Application No: A/257/21/DOC
Registered: 3rd December 2021
Site Address: Land at West End Nursery Roundstone Lane Angmering BN16 4AX
Description of Works: Approval of details reserved by condition imposed under A/144/15/PL relating to condition 15-ecological enhancement scheme.

Figure 1: Management Plan and ecological enhancement measures

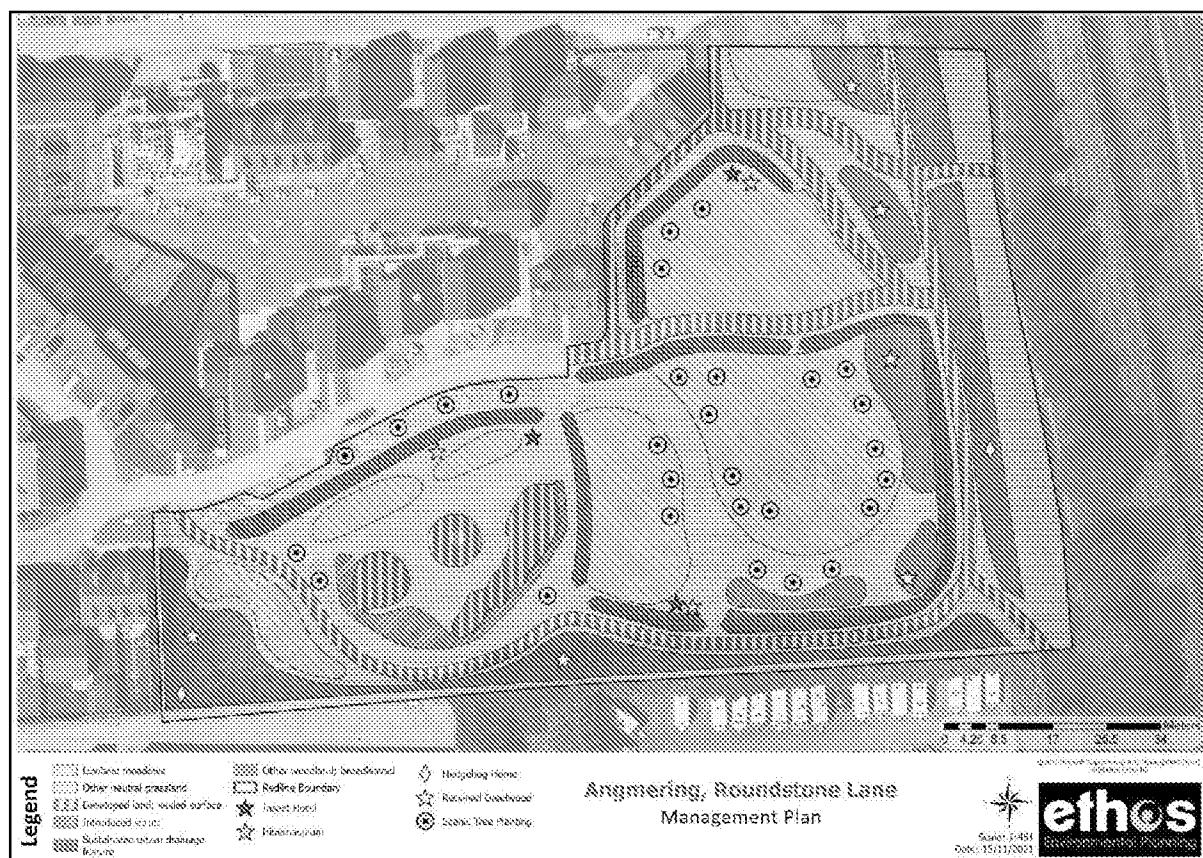
There are a couple of things with this application. The ecological report states that they are no longer able to install an attenuation basin and proposed a number of swales instead – does this constitute a material change? And has this change been sent to drainage engineers for comment? It looks as though the reason for this is improper site management.

Secondly the management plan and ecological enhancement measures (figure 1) is illegible. Is there anyway of obtaining a clearer copy of the report? Without this, and provided the information I sufficient, I will not be able to recommend that the condition be discharged.
